Application No: EP/9/22/HH
Site Address: 4 Selhurst Close East Preston BN16 2SR
Description of works: Single storey front extension and conversion of integral garage.

Thank you for your internet representation made on 4th February 2022 which has been recorded as an objection with the comments as follows:

East Elevation  
(Front)

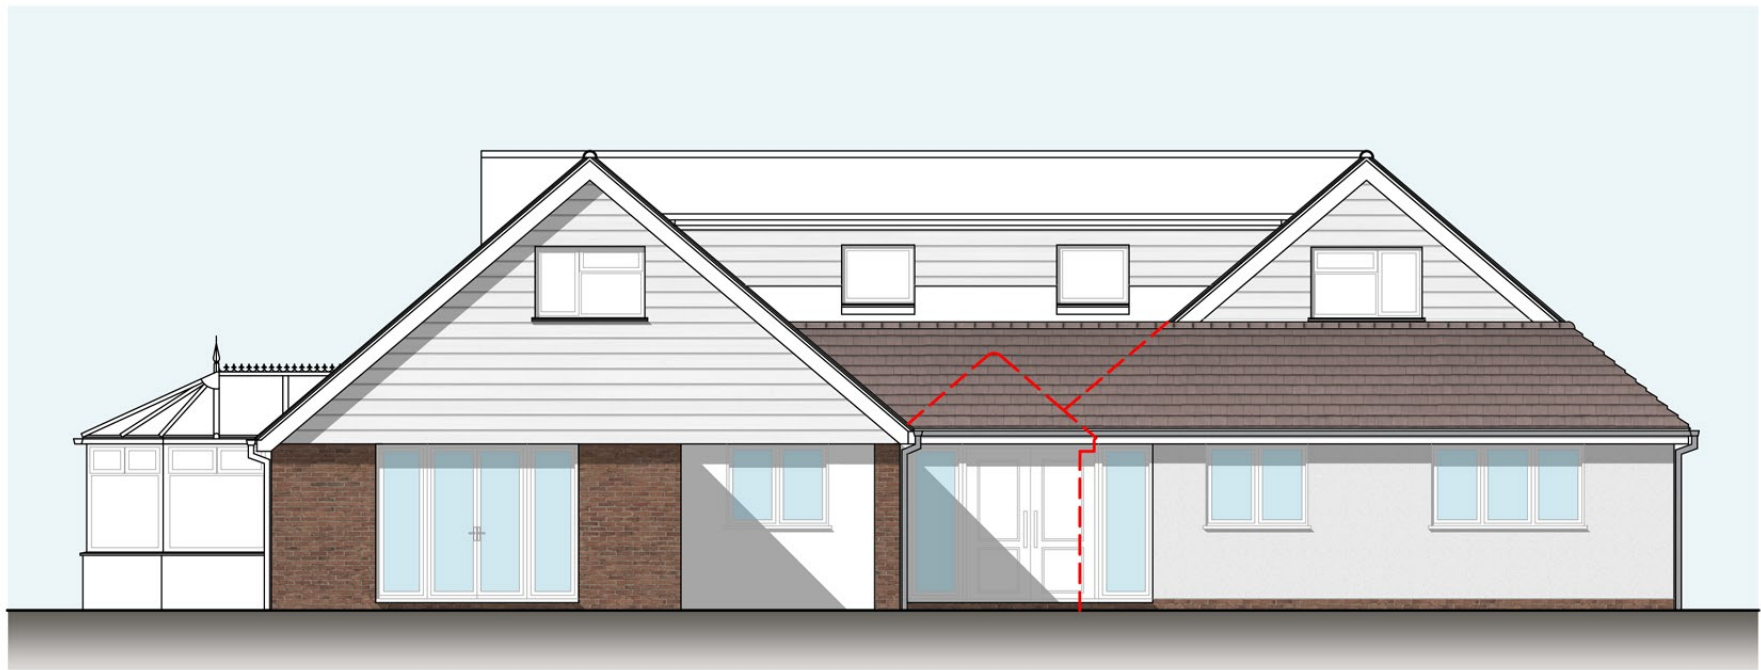
I wish to lodge an objection to the proposed installation of roof lights on the east-facing roof. This would destroy the much-valued privacy of my rear garden, which is not overlooked at present by any neighbouring property.
